re: Geotechnical Response to City Comments
Proposed Residential Development
100 Steacie Drive, Ottawa, Ontario
to: Brigil - James Battison - jamesbattison@brigil.com
date: June 1, 2026
file: PG5788-MEMO.04

Further to your request and authorization, Paterson Group (Paterson) prepared the following memorandum to provide geotechnical responses to city comments regarding the proposed residential development, at the aforementioned site. This memorandum should be read in conjunction with Paterson Group Report PG5788-1 Revision 4, dated December 8, 2026.

**PLAN VIEW:**

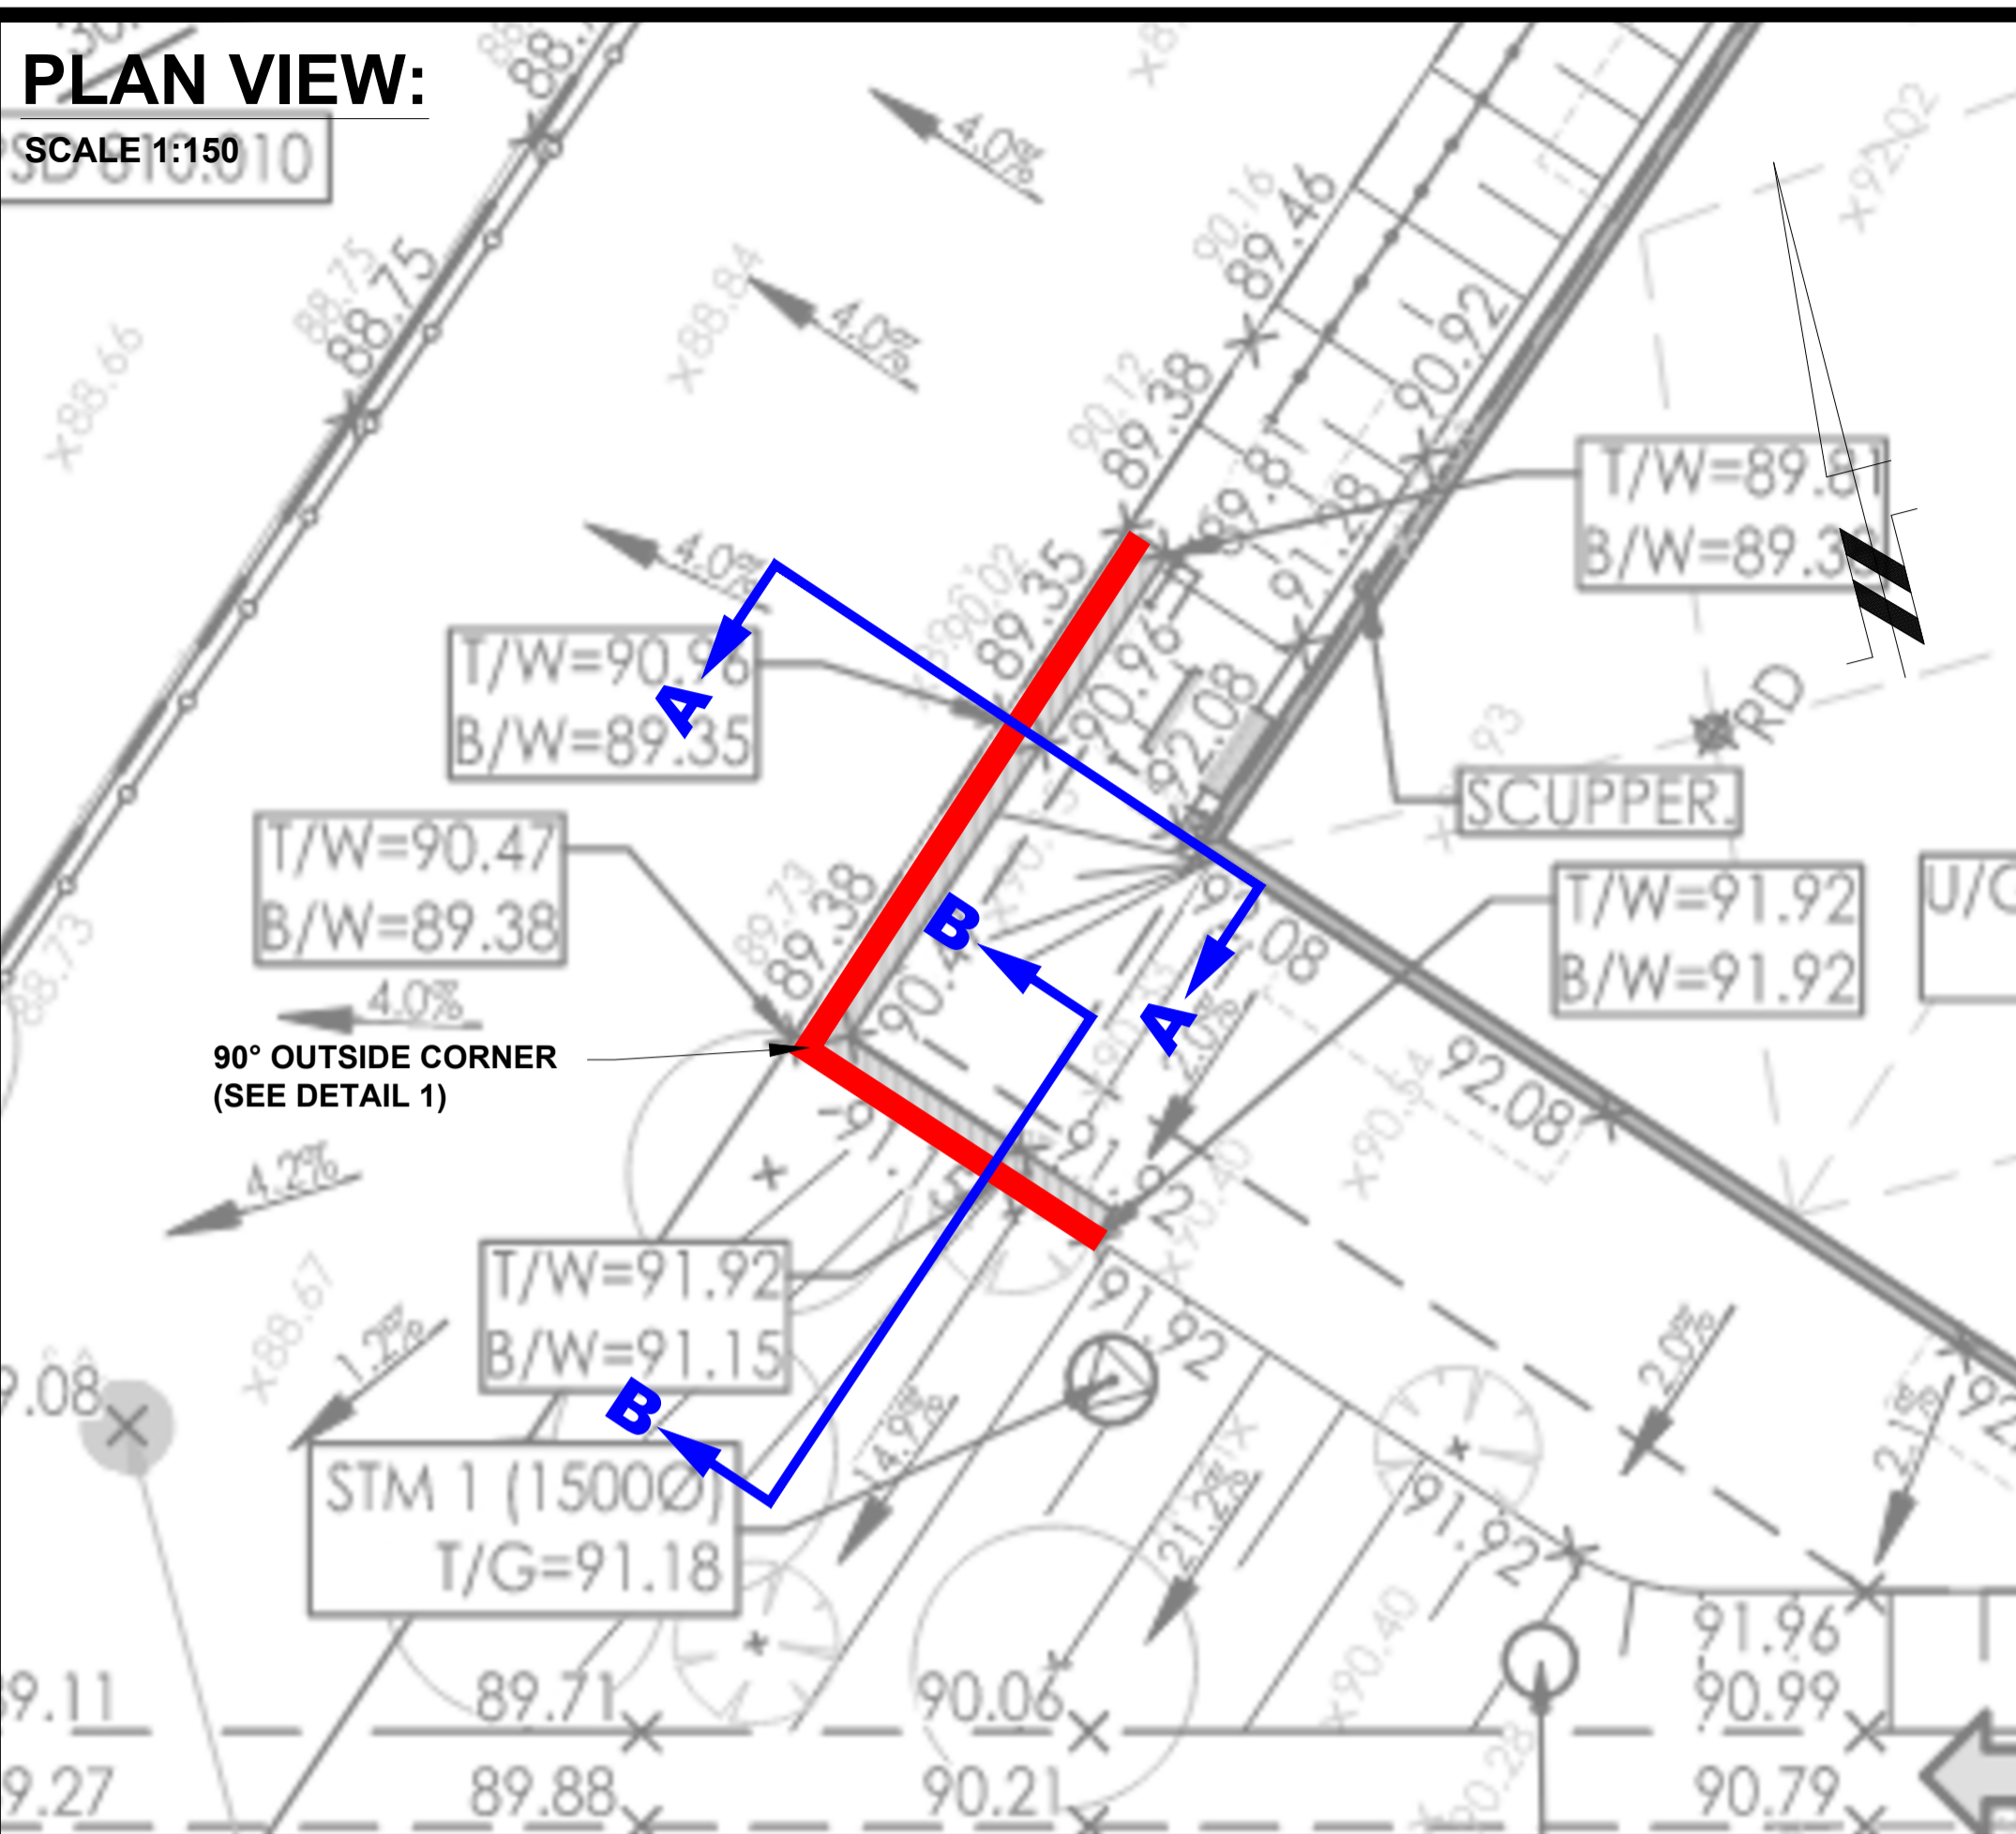
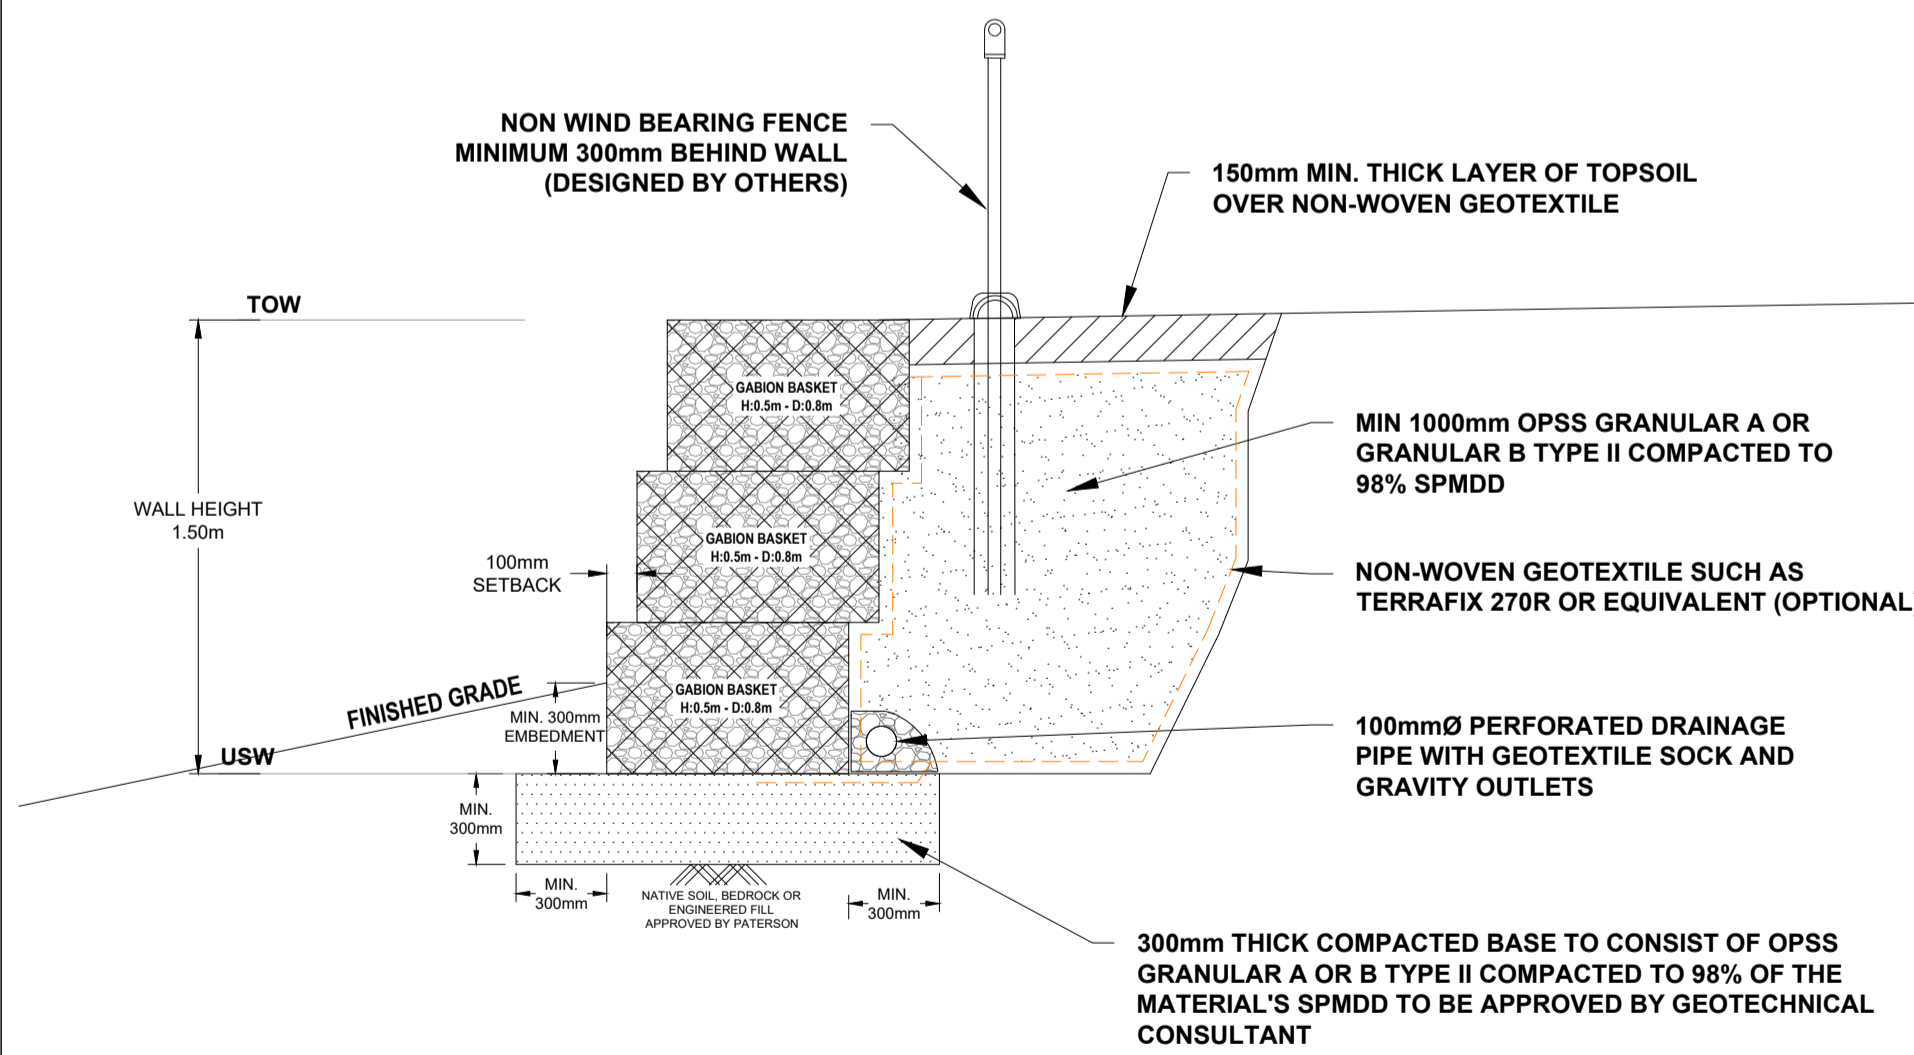
Comment 4: *This memo and associated retaining wall drawings must clearly demonstrate that the proposed retaining wall footing will not encroach onto the adjacent future 6 m wide City-owned watermain easement. Perhaps adding the easement line on the retaining wall cross-sections as a reference point would help confirm that the wall does not encroach onto the easement. Adding a note to plan view would be helpful too.*

Response: Based on our review of the grading plans, the retaining wall base will not encroach into the hydro easement. The retaining wall drawing will be updated to show the limits of the hydro easement.

Comment 2: *Section 2.0 must confirm that the new watermain and existing sanitary sewer are located outside the lateral support zone of the proposed retaining wall PG5788-3.*

Response: Based on our review of the site servicing drawing Project No. 160401570 – Drawing No. SSP-1 Revision 8, dated March 24, 2026, the proposed watermain will be located outside the lateral support zone of the retaining wall.

The existing sanitary pipe is located approximately 9 m below the proposed retaining wall. Due to the depth of the existing sanitary service from the bottom of the retaining wall, no loading will be exerted from the retaining wall to the sewer. Furthermore, any maintenance to the deep sewer will require the use of shoring/temporary trenches boxes to be feasible which will further protect the service. Reference should be made to Figure 1 attached below.

**CROSS SECTION A-A:**

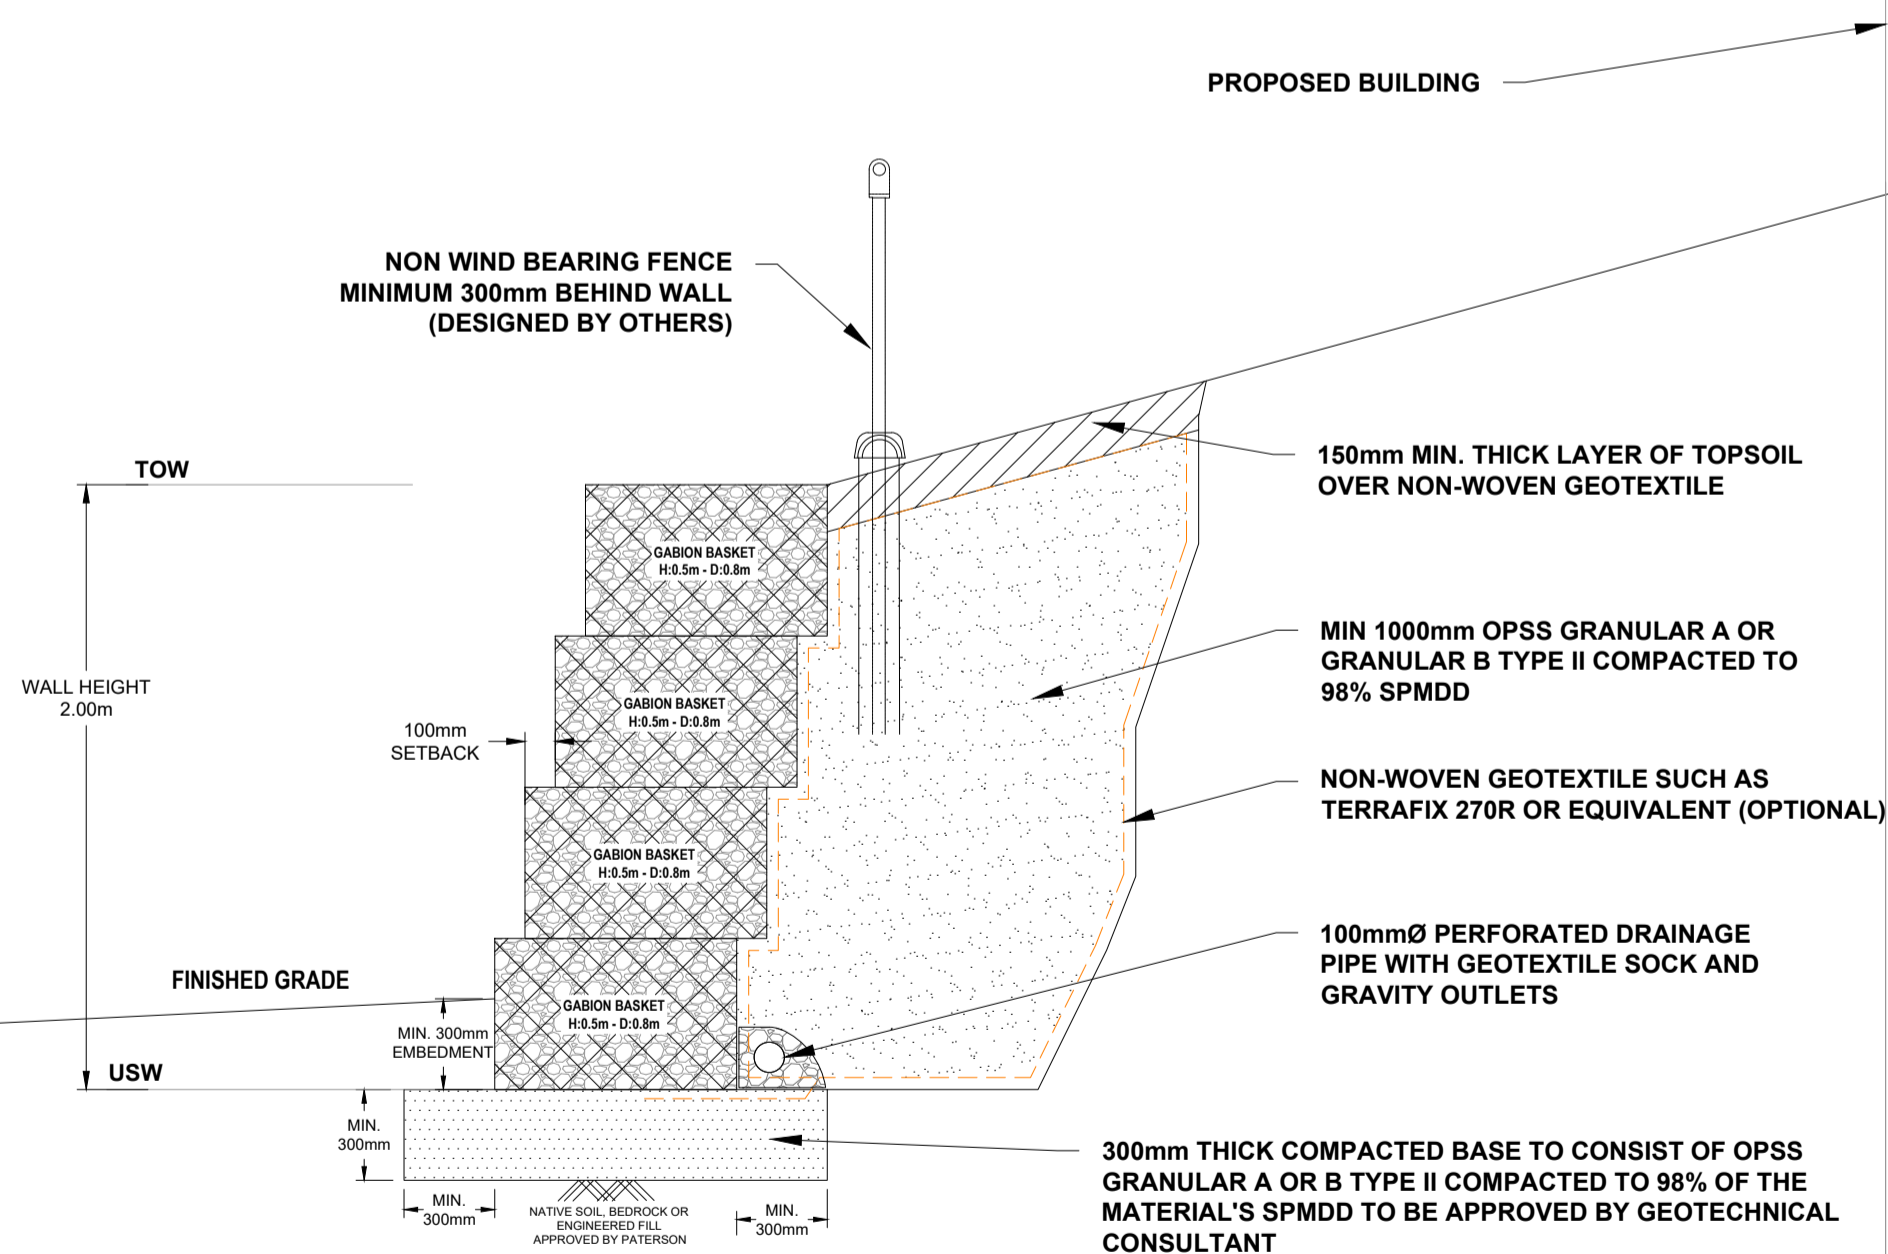
- b) Please confirm that a slope stability analysis is not needed anywhere else on site. For instance, beside the underground parking garage ramp, where +20% terracing is proposed (from 90.89 to 88.04), or, to the northeast side of the site, where +32.7% terracing is proposed (from 92.08 to 89.09). Were those areas deemed less critical than Cross-Section A?*

- c) The slope stability assessment for the proposed berm has been carried out assuming groundwater conditions well below the ground surface. It is not clear that this assumption reflects critical or reasonably foreseeable conditions. In particular, periods of intense rainfall and/or spring snowmelt may result in elevated pore water pressures and partial or full saturation within the silty clay fill, which could adversely affect overall stability. With this said, the Consultant is requested to provide clarification on whether the analysis has considered transient or worst-case groundwater conditions, including elevated water levels within the berm associated with saturated conditions. If not, the*

assessment should be updated to evaluate slope stability under these conditions to demonstrate that adequate factors of safety are maintained.

- b. Based on our review the cross-section A- A was selected as the critical section where the berm has the highest slope and retaining wall section with a maximum height of 1.5 m. Based on our analysis, the global stability of the proposed retaining wall and the berm were observed to be stable under static and seismic conditions where a factor of safety more than 1.5 and 1.1, respectively was calculated. Based on this, all the other slopes within the site are considered acceptable from a geotechnical perspective, provided any fill placement is completed in accordance with our geotechnical recommendations. Slope of less than 33% (3:1) are inherently stable and are not normally reviewed by the geotechnical consultant.

- c. The slope stability analysis considering fully saturated groundwater conditions within the berm was also calculated and the factor of safety was still calculated to be more than 1.5 and 1.1 under static and seismic conditions. Refer to Paterson memorandum PG5788-MEMO.03, Revision 3, dated May 26, 2026.
